Action Points arising from Issue Specific Hearing 3 (ISH3) on environmental issues, held on Wednesday 25 March to Friday 27 March 2026. Historic England response.

Illus 07 - Overall interpretation of magnetometer data

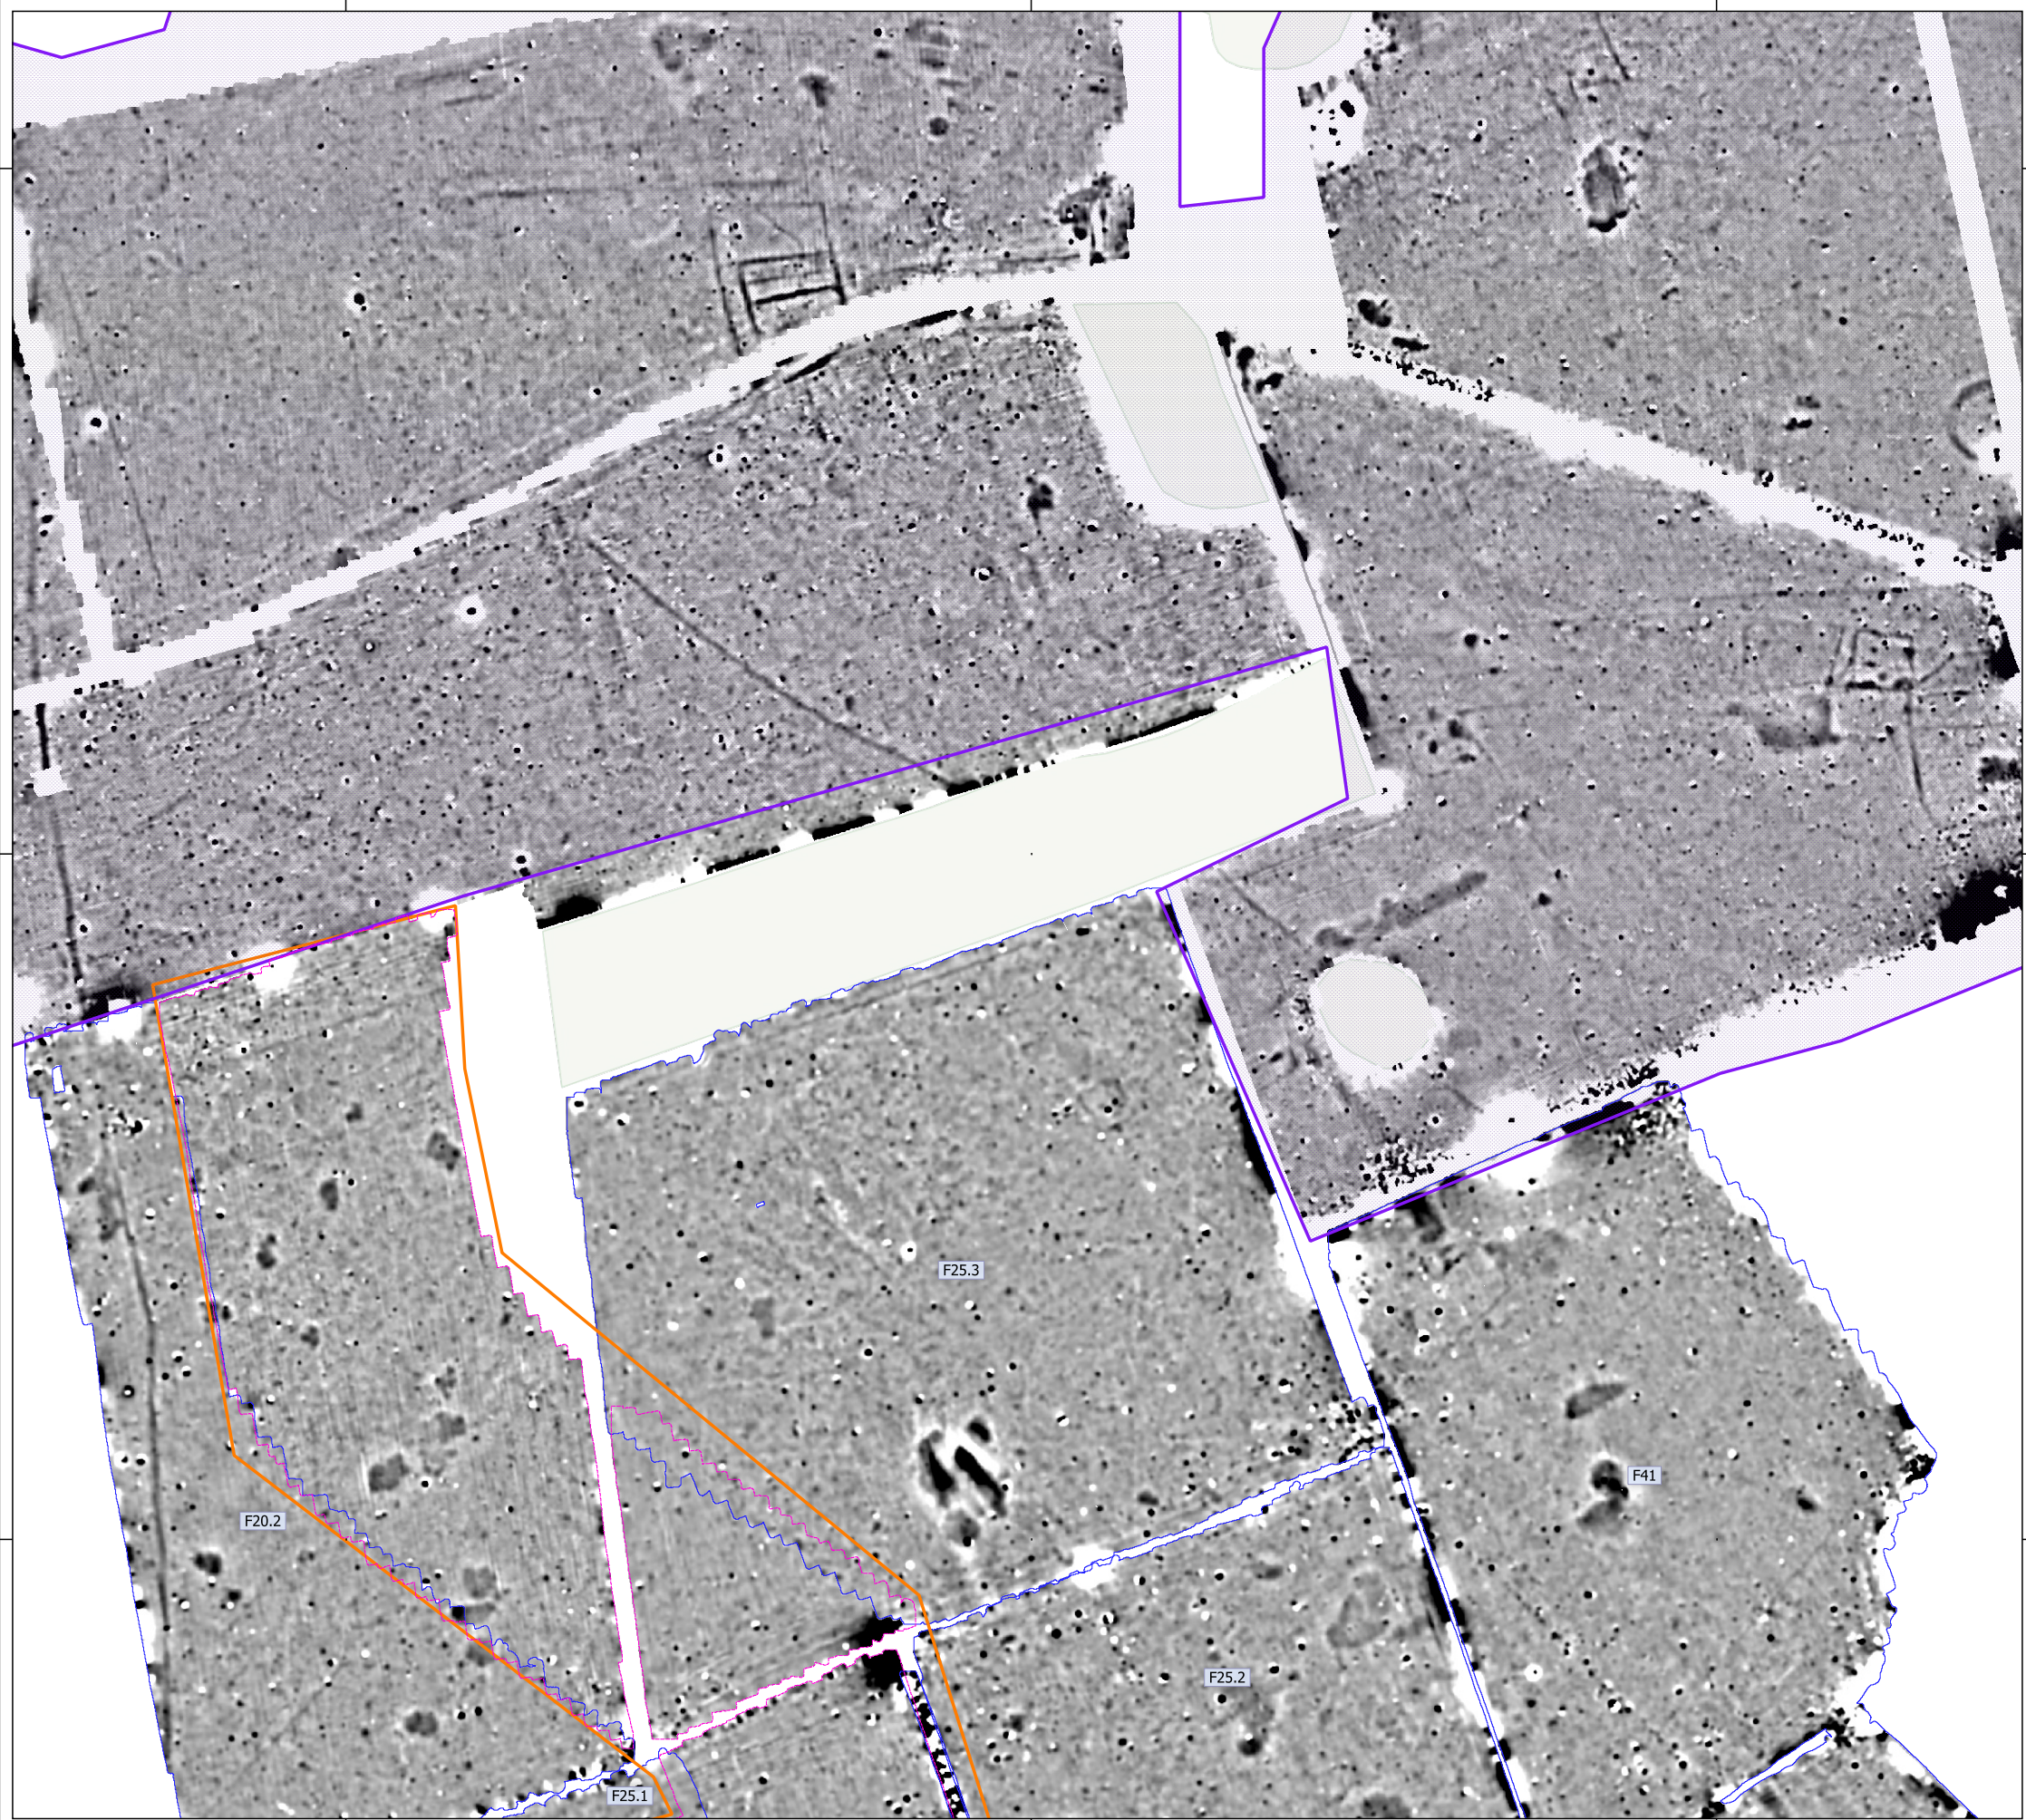
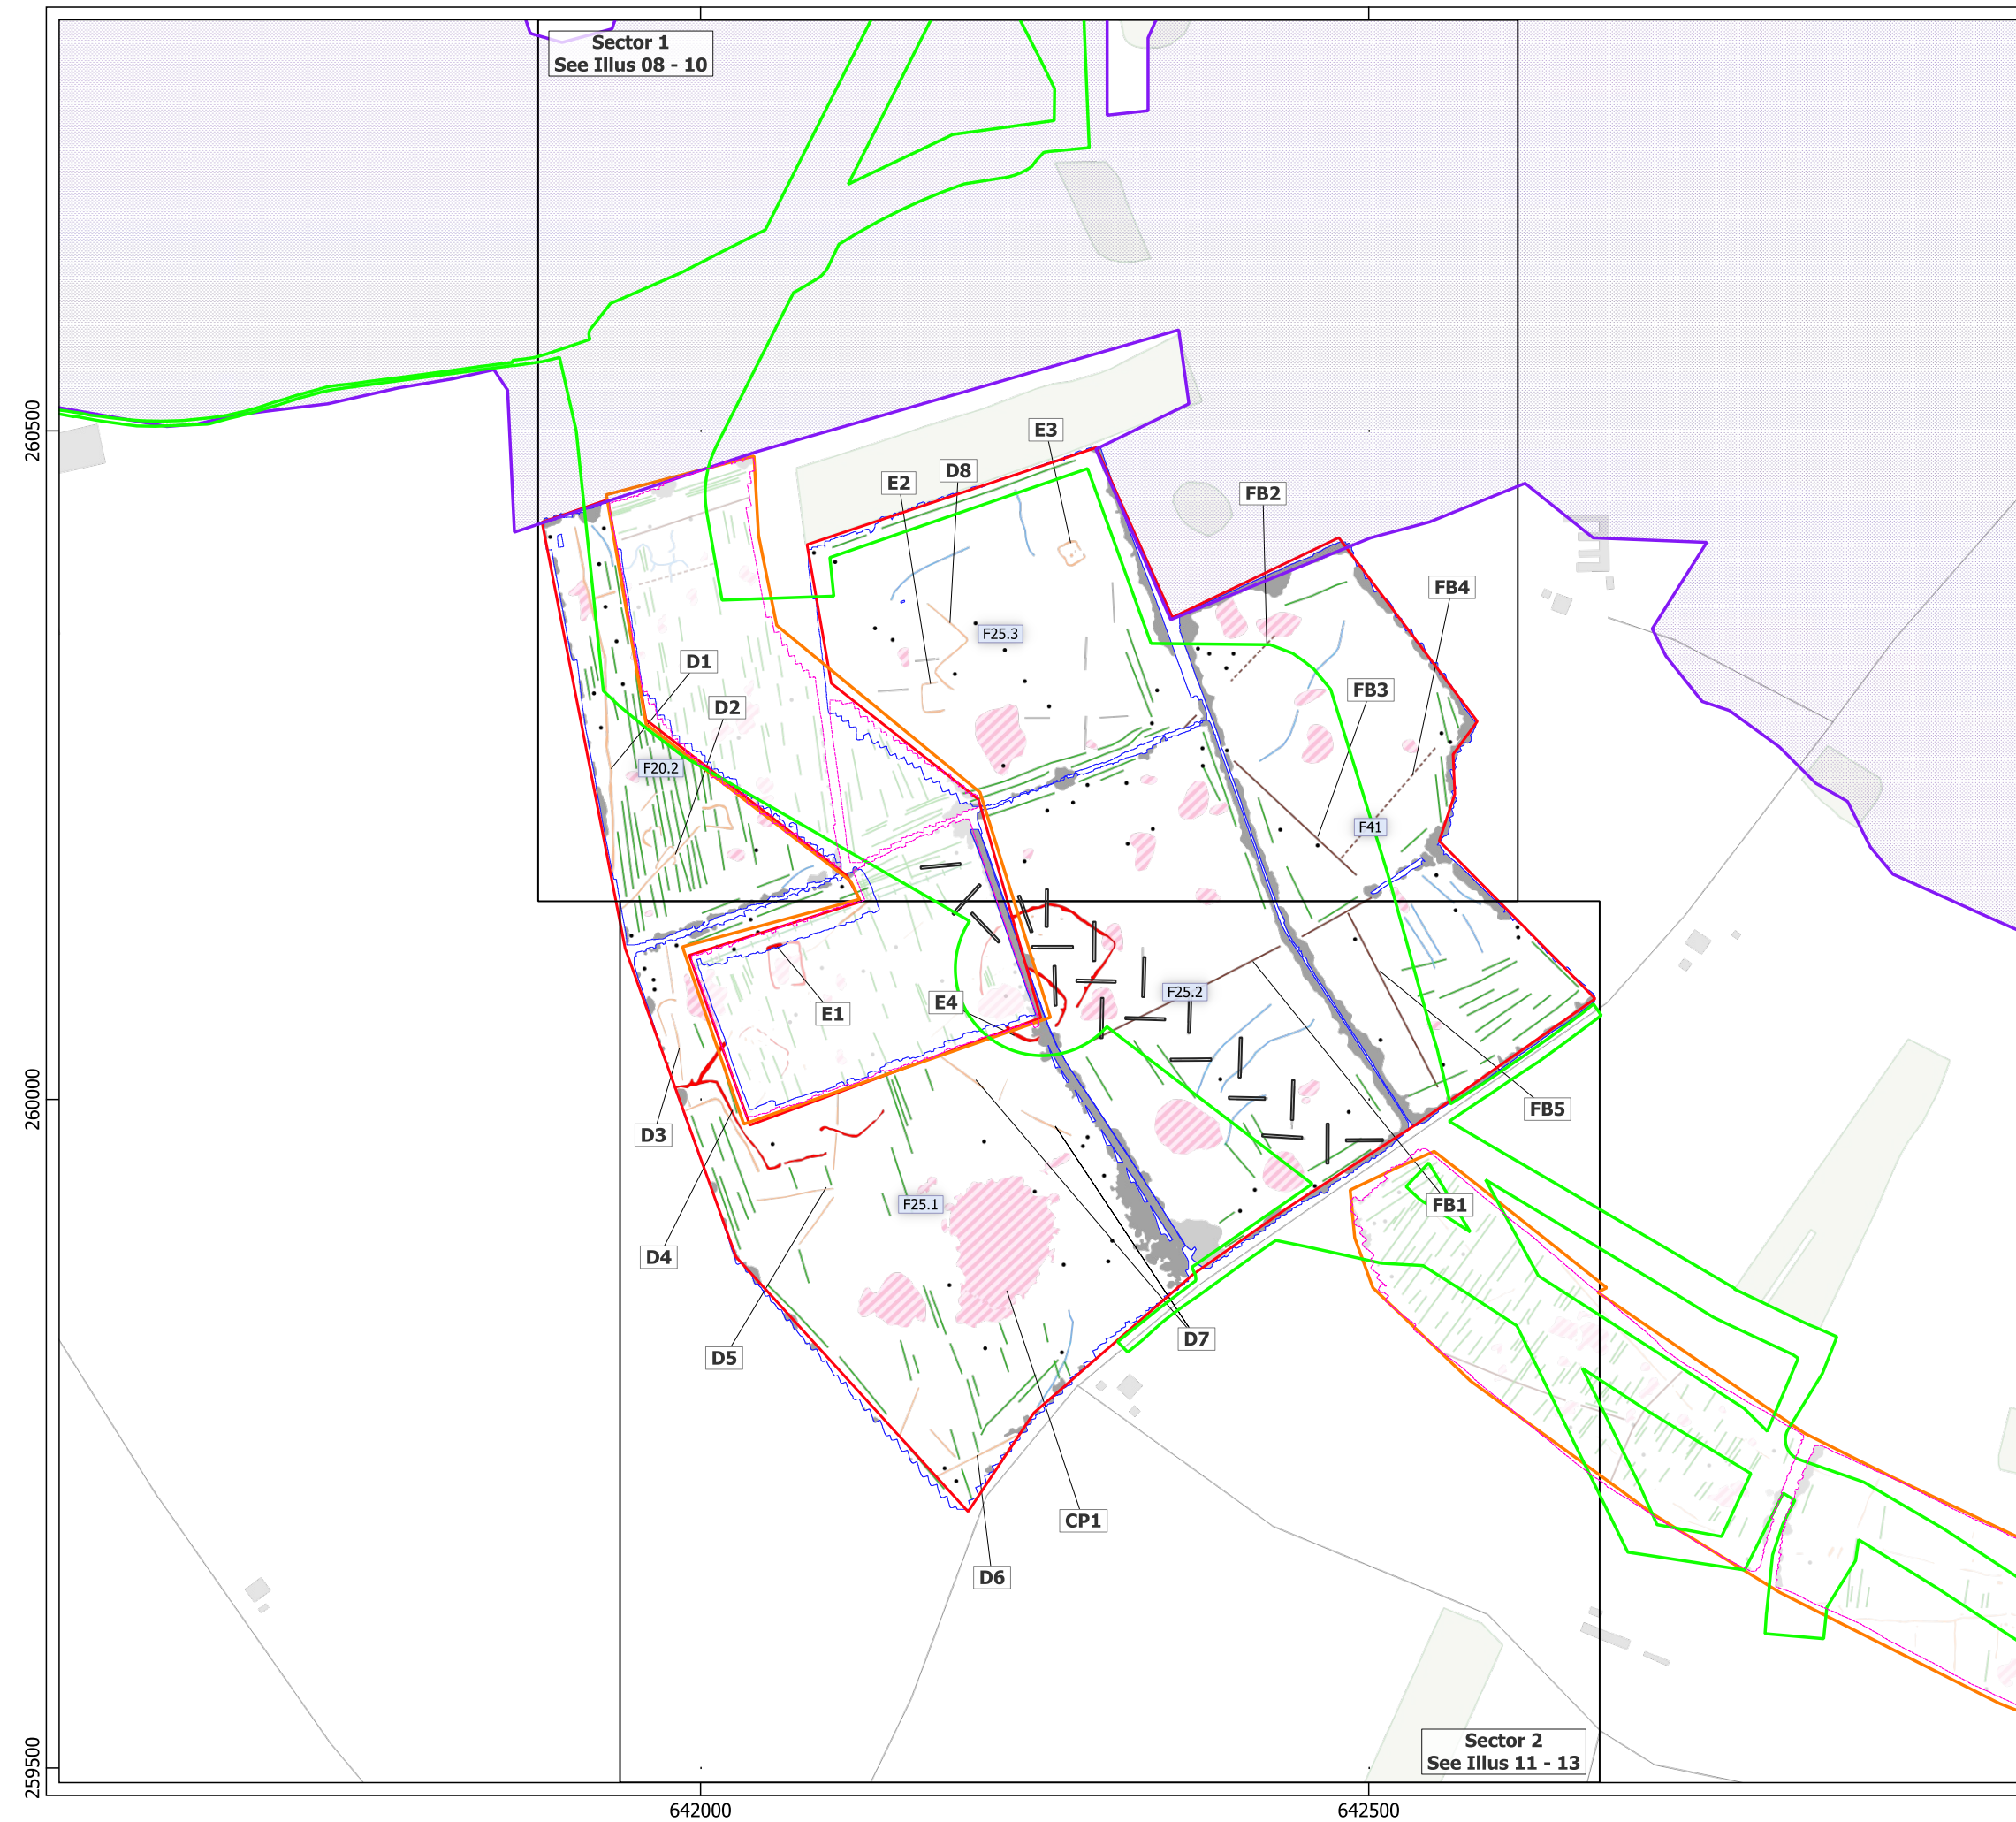
40	Historic England	<p>Is Historic England satisfied with the current level of information and the approach the applicant has set out in regards to the D-shaped enclosure in Suffolk?</p>	<p>The information related to enclosure identified in Suffolk (Fields F25.1 and F25.2) has been presented by the applicant in the following documents:</p> <ul style="list-style-type: none"> - Suffolk Section Phase 2B Archaeological Evaluation Report [AS-136] - Change Request Appendix B Geophysical Survey Report [CR1-057] - Suffolk Phase 3 Archaeological Evaluation Final Report [REP5-140] <p>Historic England is satisfied with the level of information and assessment provided by the applicant in respect to this non-designated archaeological site. We consider that the enclosure is likely of regional importance, as assessed in an Addendum to Volume 6 Environmental Statement [CR1-055].</p> <p>Addendum to Volume 6 Environmental Statement [CR1-055] outlines that two options for mitigation of the enclosure area which are being considered: re-routing of the cable and haul road corridor to the east to avoid impact on the enclosure; and archaeological excavation of the entirety of the enclosure to allow for the original route of the cable and haul road.</p> <p>The applicant confirmed during the ISH3 that the currently preferred mitigation measure is</p>

<p>avoidance of the enclosure and re-routing of the works corridor to the east (Transcript of Issue Specific Hearing 3 (ISH3) - Day 2 - Part 2 - 26 March 2026), as no significant archaeological remains have been identified in that area during most recent phase of trial trench evaluation [REP5-140]</p> <p>We understand that both options for proposed mitigation measures have been agreed with Suffolk County Council Archaeological Services. They are the appropriate authority for the provision of advice on the mitigation measures for non-designated heritage assets.</p> <p>We support outlined approach to mitigation and have no further comments to make.</p>
41	Historic England	With regards to Richborough Saxon Shore Fort, Roman Port, and Associated Remains in Kent, based on the applicant's submitted details and information, how would Historic England consider the potential impact to the setting and significance of these heritage assets?	<p>Historic England continues to maintain that the proposed development would result in a higher level of harm to Richborough Roman Fort than has been assessed by the applicant.</p> <p>As we previously highlighted in our Written Representation the applicant has assessed the magnitude of harm to the significance of the fort caused by development within its setting (during operation and maintenance) to be 'Negligible' with a resultant 'Minor Adverse' significance of effect ([APP-063] Table 3.14, pg. 65).</p>
